Development Control
Ribbles Valley Borough Council

Re: Planning Application 21/0076

Address: Queen Mary Terrace and Bridge Terrace Mitton Road Whalley BB7 9JS

Description: Proposed demolition of 34 existing dwellings and the erection of 50 new dwellings with vehicular accesses, landscaping and other associated works.

Drawing file: planx_downloads / 21_0076_Amend_Site_Layout_2510.PDF

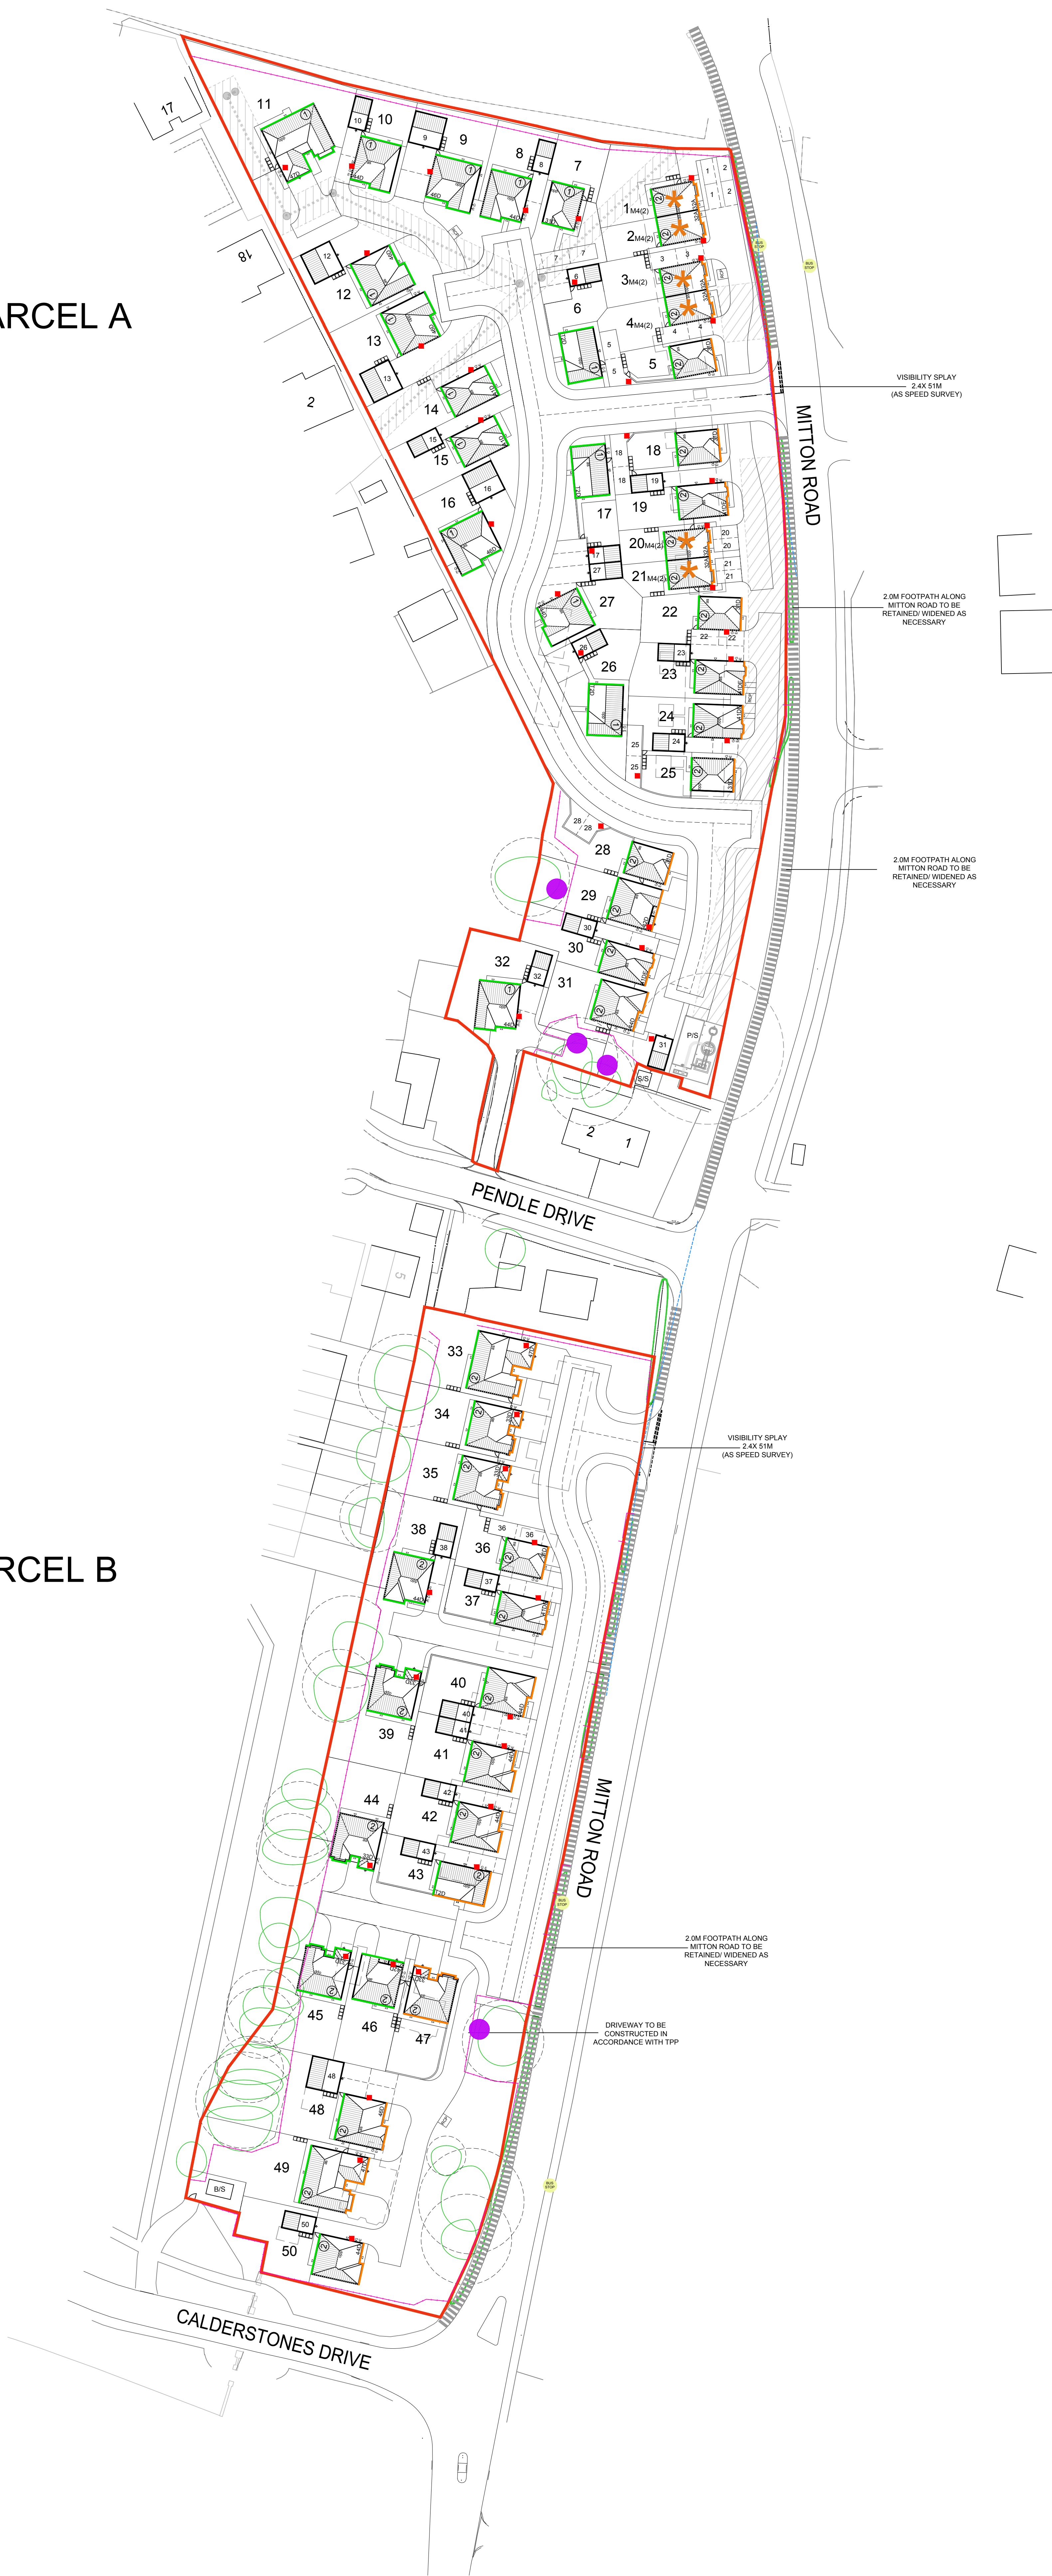
- Provision of 2 metre footways along the frontage of the site, there are areas where the footways are already 2 metres and where the hedgerow has overgrown onto the footway.
- Traffic Calming Measures such as enhanced road markings at the 30mph speed limit change which will be agreed as part of the S278 works.
- Bus Stops improvements on Mitton Road, to the two stops between Calderstones Drive and Pendle Drive and the stop opposite Mitton Road Business park
- The provision of tactile paving as requires at Calderstones Drive and Pendle Drive
- The reinstatement with dropped kerbs of the footway of Pendle Drive at and opposite Plot 32.
